From: Graham Evans
Sent: 03 December 2008 10:16
To: Planning.Responses
Subject: FW: Planning Consultation on: FP/231/08/

APPLICATION FP/231/08/
NO:

Registered: 27-NOV-08
Site 108 Felpham Road Bognor Regis
Address:

Description of Works: Internal shopfit including installation of airconditioning system and associated external condenser.

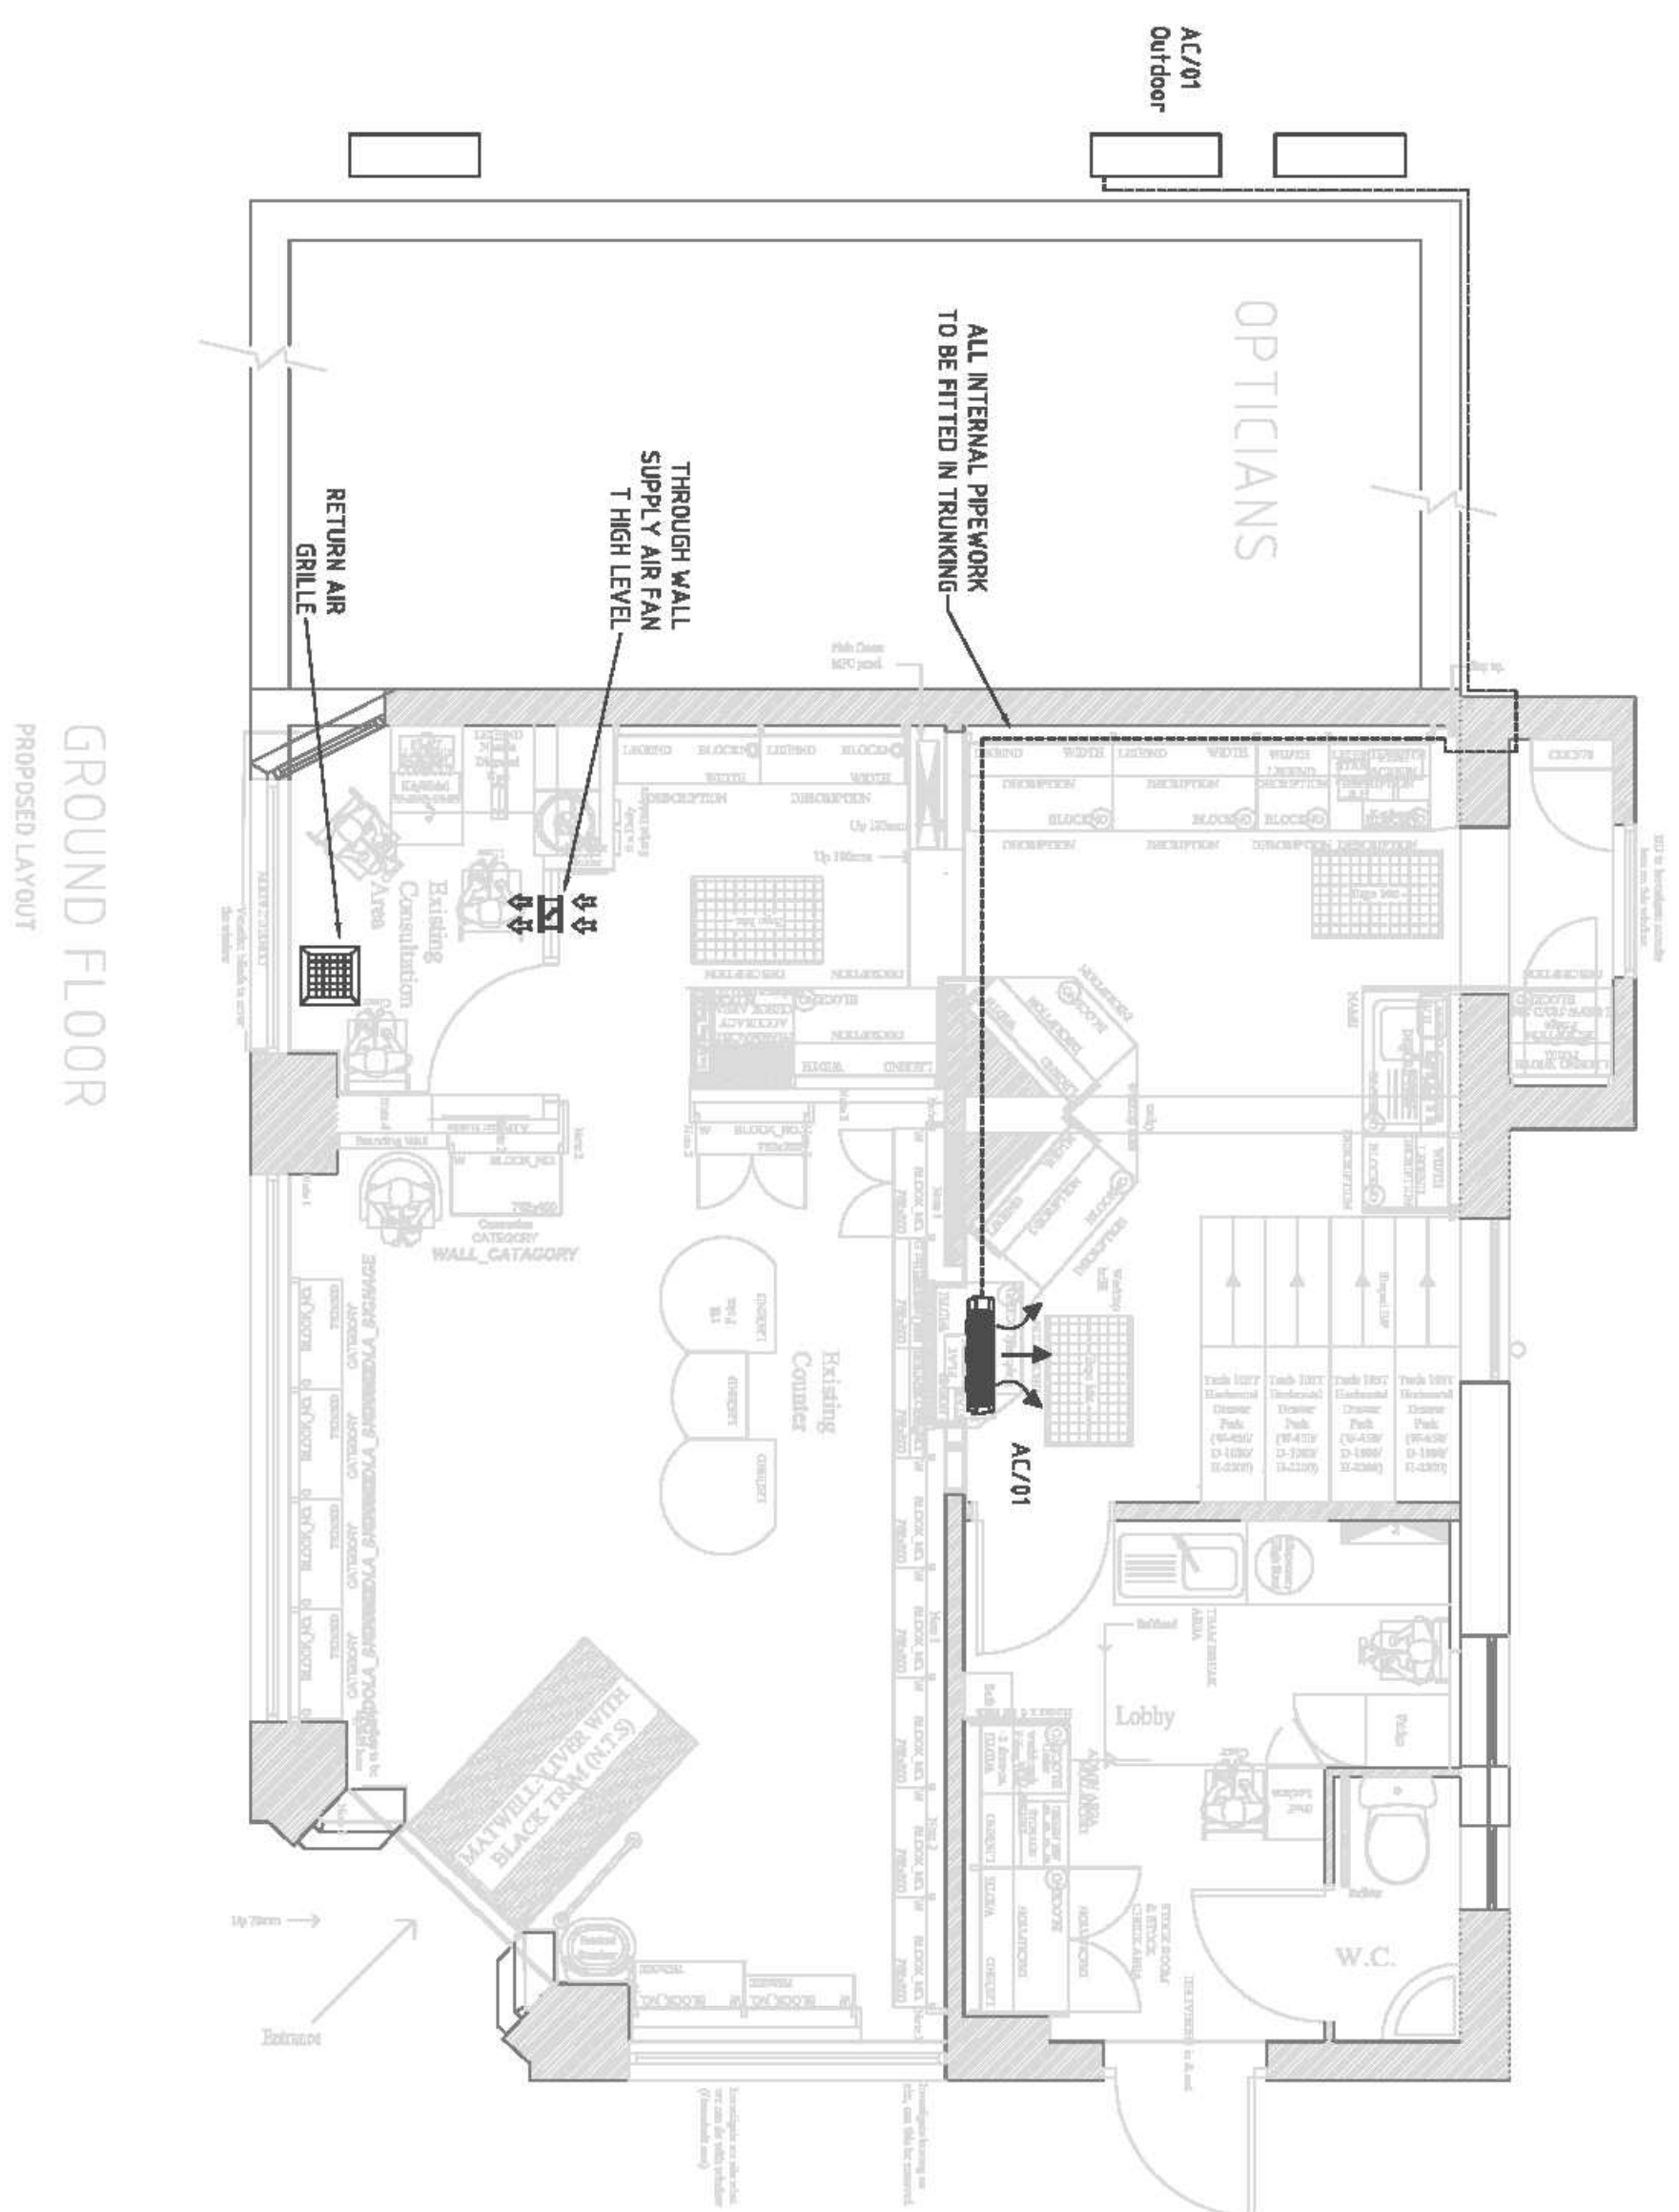
There is insufficient information in the application to enable the determine the sound pressure level from the A/C unit at the nearest noise sensitive premises, believed to be a first floor flat above the shop? However it appears from photographs that the external A/C unit has already been installed alongside two existing A/C units that have not given rise to previous complaint. It is assumed that the A/C unit will only be operational during shop opening hours and it is therefore unlikely that the additional unit will have significant impact on local amenity by way of noise. No objections.
